Application Ref.: F/4/20/OUT

Proposal: Outline planning application (with all matters reserved except for access) for the development of up to 1,500 dwellings (Use Class C3), 60-bed care home (Use Class C2), up to 9,000 sqm. of employment floorspace (Use Classes B1), local centre of up to 2,350 sqm including up to 900 sqm retail/ commercial (Use Classes A1-A5) and 1,450 sqm community/ leisure floorspace (Use Classes D1-D2), land for a two-form entry primary school (Use Class D1), public open space, allotments, new sports pitches and associated facilities, drainage, parking and associated access, infrastructure, landscape, ancillary and site preparation works, including demolition of existing buildings and part removal of existing runway hardstanding.

Location: Land at Ford Airfield Ford

This representation has been prepared on behalf of Ford Energy from Waste Ltd. Ford Energy from Waste Ltd is a joint venture company owned by Viridor Waste Management Ltd and Grundon Waste Management Ltd, both significant waste management operators in the UK. Ford Energy from Waste Ltd is currently developing plans for an energy recovery facility on the strategic waste site allocated at Ford, cur

Figure 33: Outline Planning Application Parameter Plans - presented in detail on the following pages

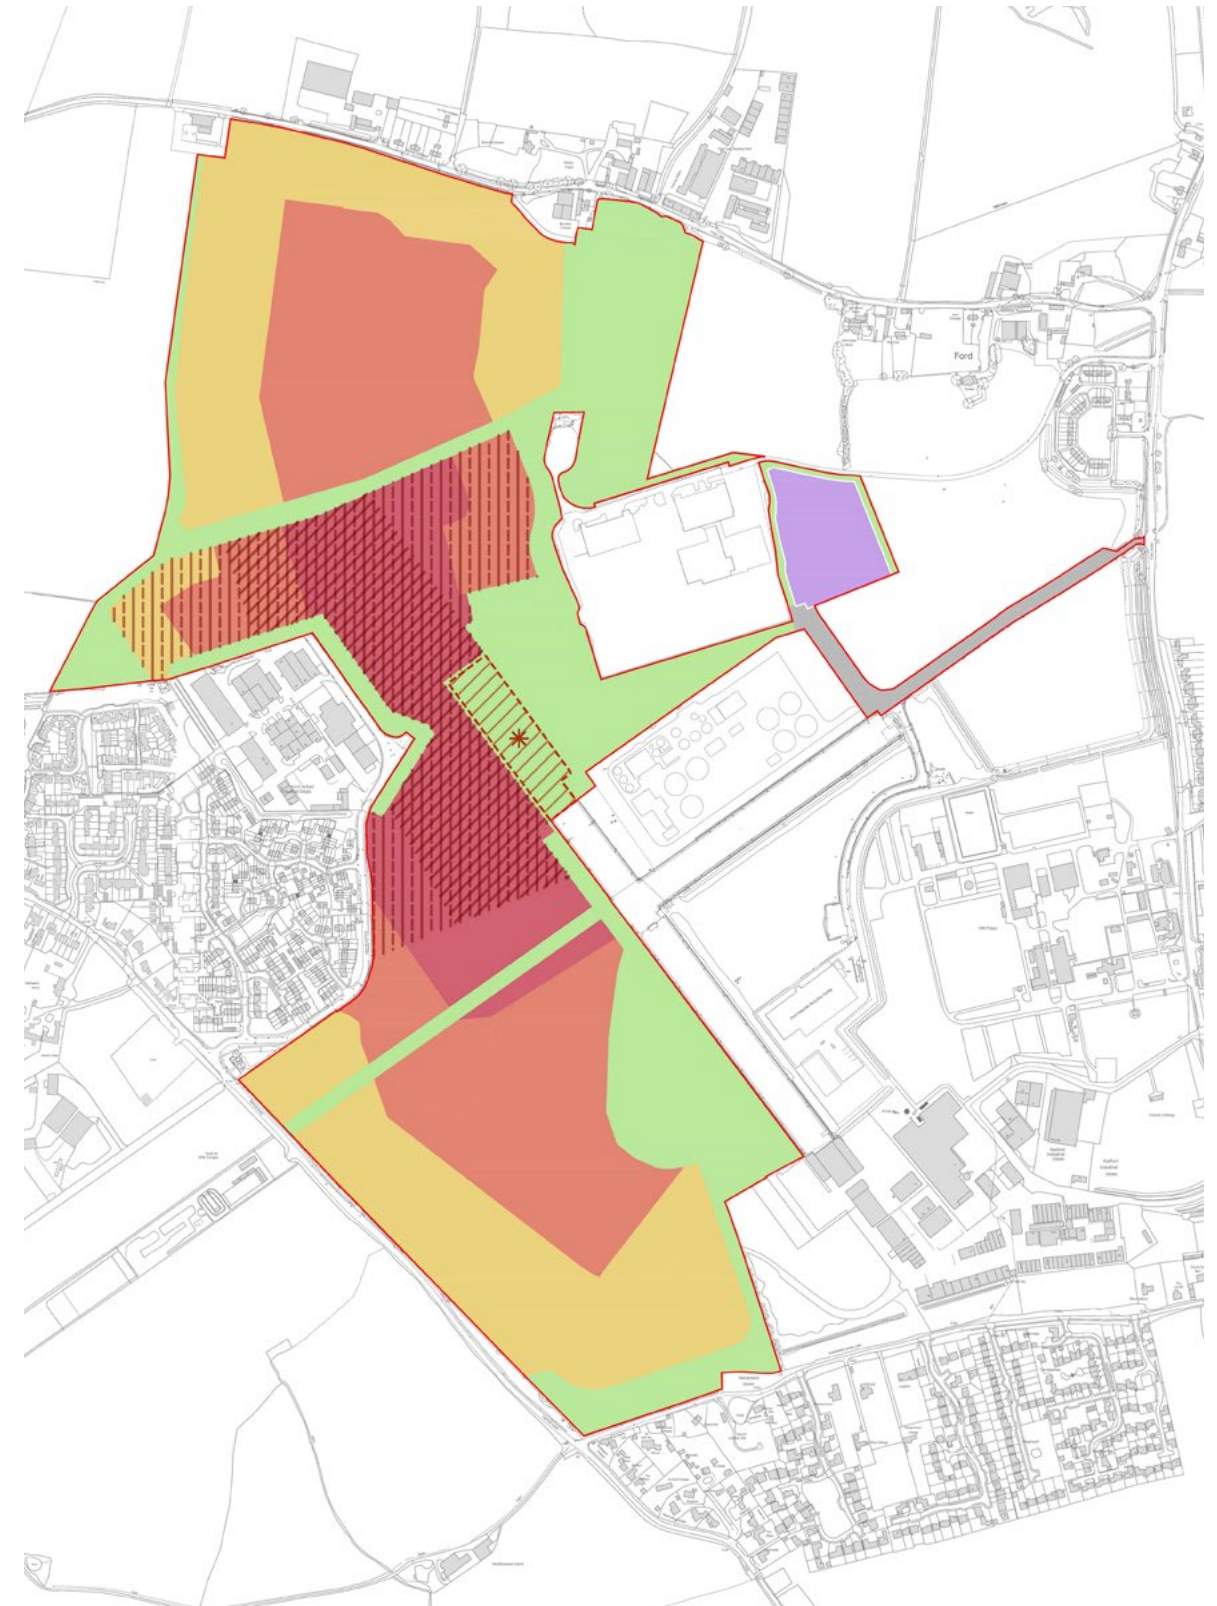
impacts beyond the site boundary. It is for this reason that waste management facilities are typically strategically located a reasonable distance from sensitive receptors, such as residential properties and offices. Suitable sites are therefore very difficult to identify and those that are identified are strongly protected by national and local planning policy. The layout proposed in the planning application shown on both the Illustrative Masterplan and the Land Use & Density Parameter Plan (Drawing RG-M-123) is therefore of significant concern.

clear that the current scheme has not been appropriately assessed or designed. We therefore have no option but to **object** to the Land Use & Density Parameter Plan (Drawing RG-M-123) and the proximity and density of the housing and employment uses promoted by the developer.

- The proposed layout is reconfigured to provide an optimum distance between sensitive receptors and waste management sites taking into account, noise, odour and air quality and based on realistic technical assumptions. As a working assumption the starting position should be a minimum buffer of 250m.
- Adequate mitigation measures (supported by technical assessments) are built into the scheme to ensure that the risk of complaint is minimised, and the amenity of receptors is not compromised.
